KINGS PARK METAL RECOVERY AND RECYCLING FACILITY EXPANSION

23-43 and 45 Tattersall Road, Kings Park -
Sell & Parker Pty Ltd

Response to Submissions – Additional RFIs

21 DECEMBER 2021

Figure 1: Noise contours and assessment locations presented in the ANIA

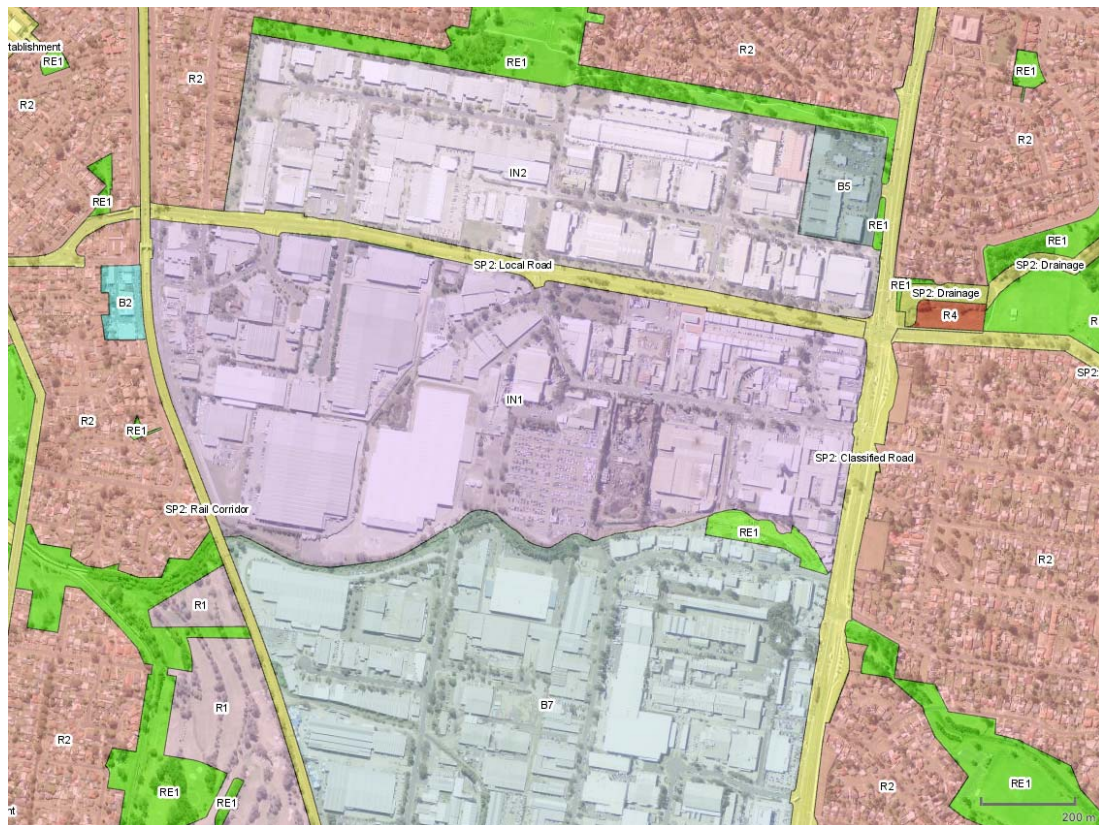
<p><u>2. Operational noise survey and modelling</u></p>	
<p>Noise contours shall be updated to display a single decibel value instead of a range of decibel values for each contour line (see Figure 1).</p>	<p>Noise contours have been updated accordingly. Refer to the Revised Addendum Noise Impact Assessment (Annexure B).</p>

Figure 3: Amended On-site Stacking Plan

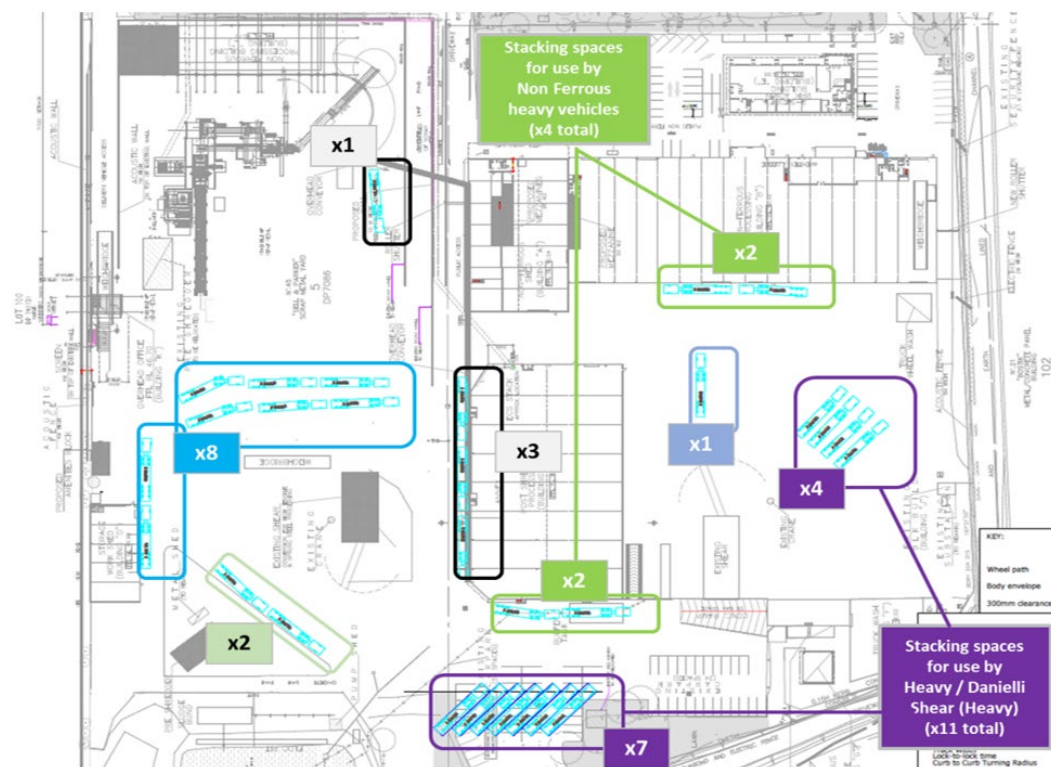
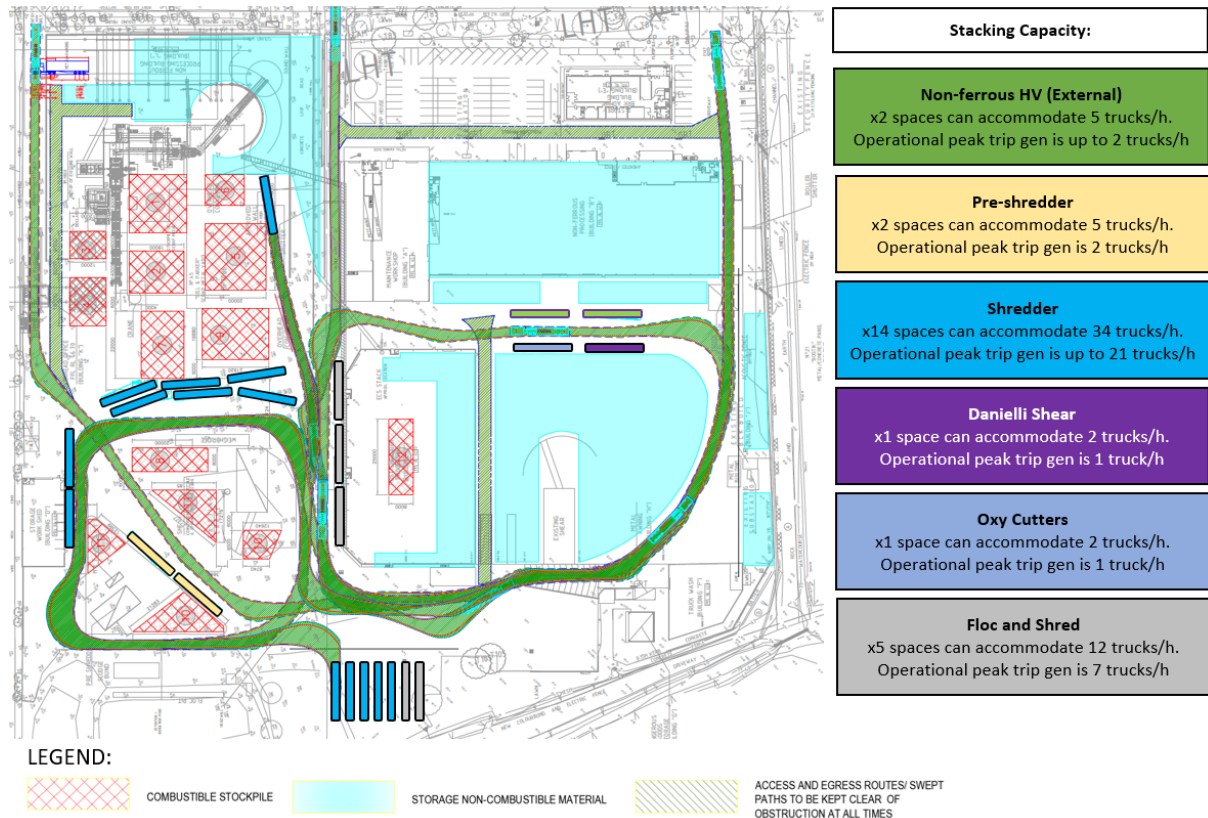
Traffic	
<ul style="list-style-type: none"> 1. It would appear that Figure 6-1 in the Traffic Assessment (Appendix E of the EIS) shows heavy vehicles queuing/stacking in areas shown as stockpiles in the SP (Appendix G of the RTS). 2. Please provide an amended Figure 6-1 that includes <ul style="list-style-type: none"> a. the proposed stockpile layouts and b. demonstrates there is sufficient room onsite for vehicle queueing. 	<p>A further amended Figure 6-1 is provided here (Annexure F) which shows the stacking arrangement in relation to stockpile locations. This demonstrates that stacking can occur outside areas designated as stockpiles.</p>
<ul style="list-style-type: none"> 3. To demonstrate the stacking analysis represents the peak operational hour, please provide a breakdown of traffic volumes by hour. 	<p>An hourly breakdown of traffic volumes is provided in Table 1 of Annexure F. This shows that the peak operational hour is 10am -11am (33 heavy vehicles and 10 light vehicles entering the site).</p>
